From: Deputy Clerk (Aldwick Parish Council) 
Sent: 01 October 2018 16:23
To: Samantha Allen
Subject: RE: Re: AW/210/18/HH - 1 Raycroft Close

Subject: FW: Re: AW/210/18/HH

PLAN 1-100

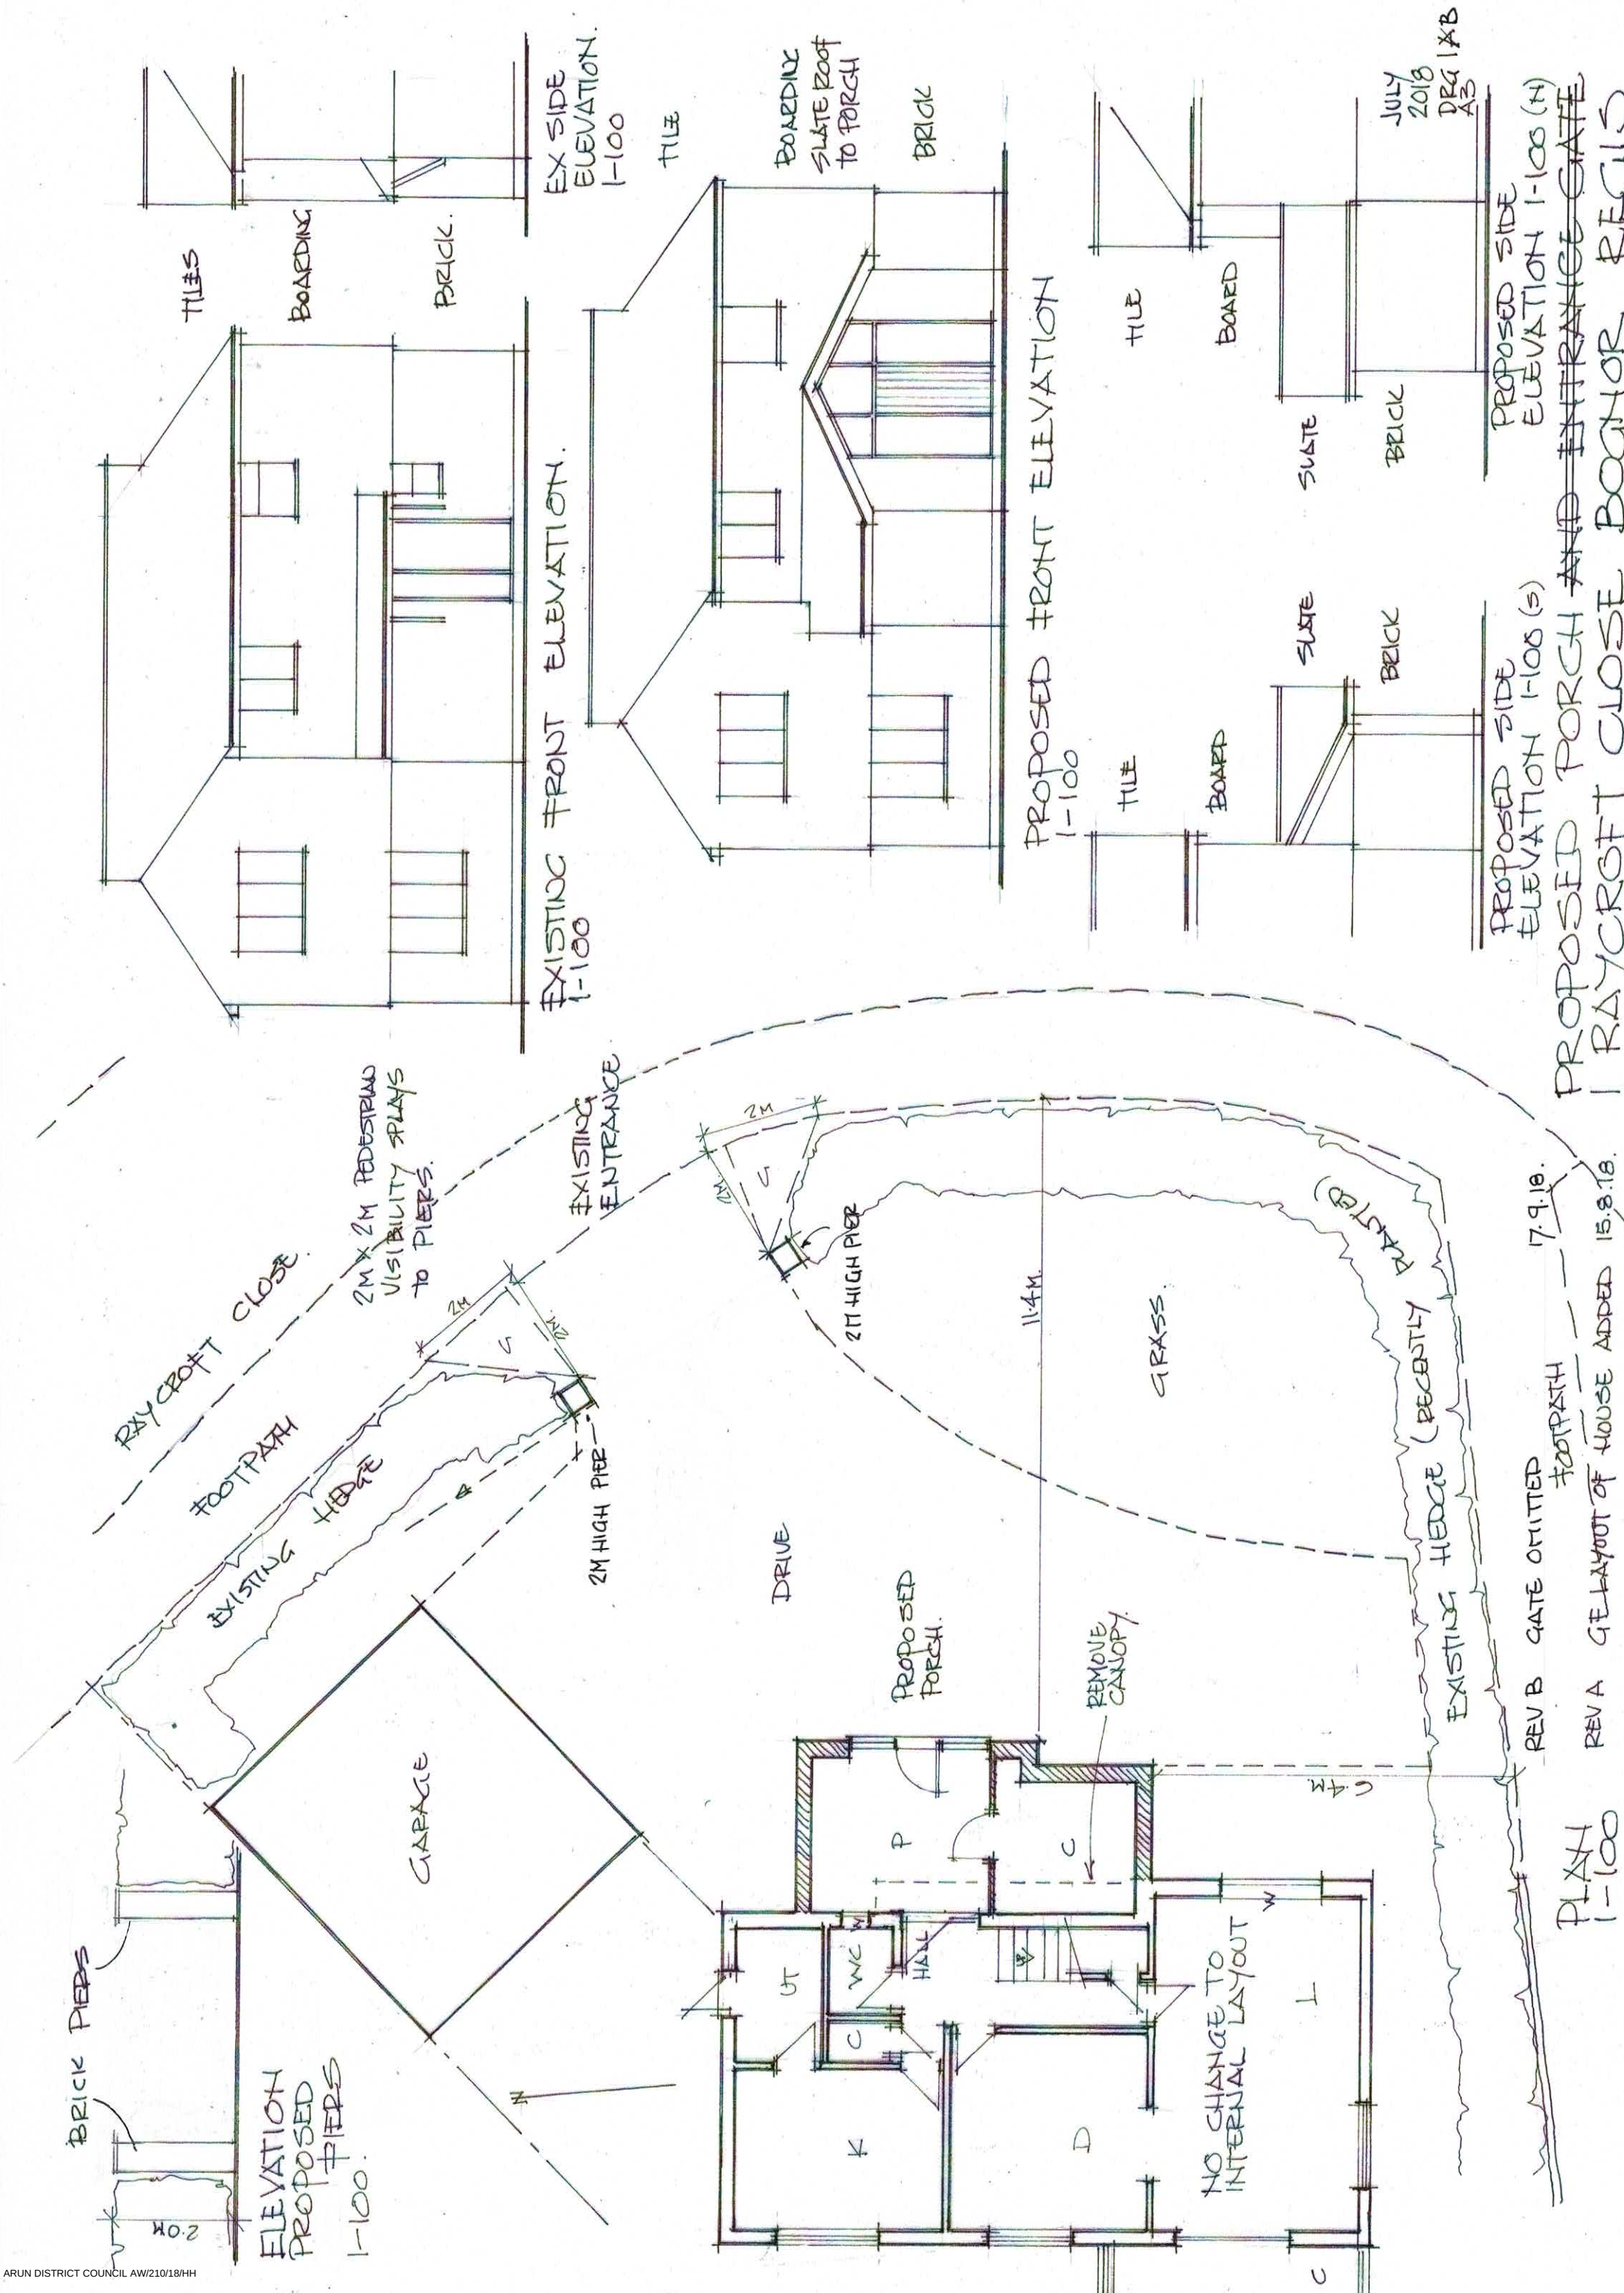
'Two pillars sitting redundant mars the open plan nature of the estate and in conflict with D DMR 4e as well as Design Statement'

Yes, the gates have been removed but the 2m tall gate piers remain on the revised plan. Why? (In order to install gates at a future date perhaps?). Notwithstanding why, the building of 2m tall piers would, in my view, be in conflict with the open plan estate policy. Therefore, as the committee said previously, I think the piers would be in conflict with Policy D DMR 4e of the Arun District Local Plan 2011-2031 and in conflict with the adopted Aldwick Parish Council Design Statement pages 55&56.

I have no objection to the porch alterations but I do have an objection to the piers. If the piers are removed from the plan I would have no objection.

I have an email from the applicant, which will be uploaded onto our website shortly, that confirms the brick piers are no longer required. Therefore the application will be assessed on the basis that it is for the porch only.
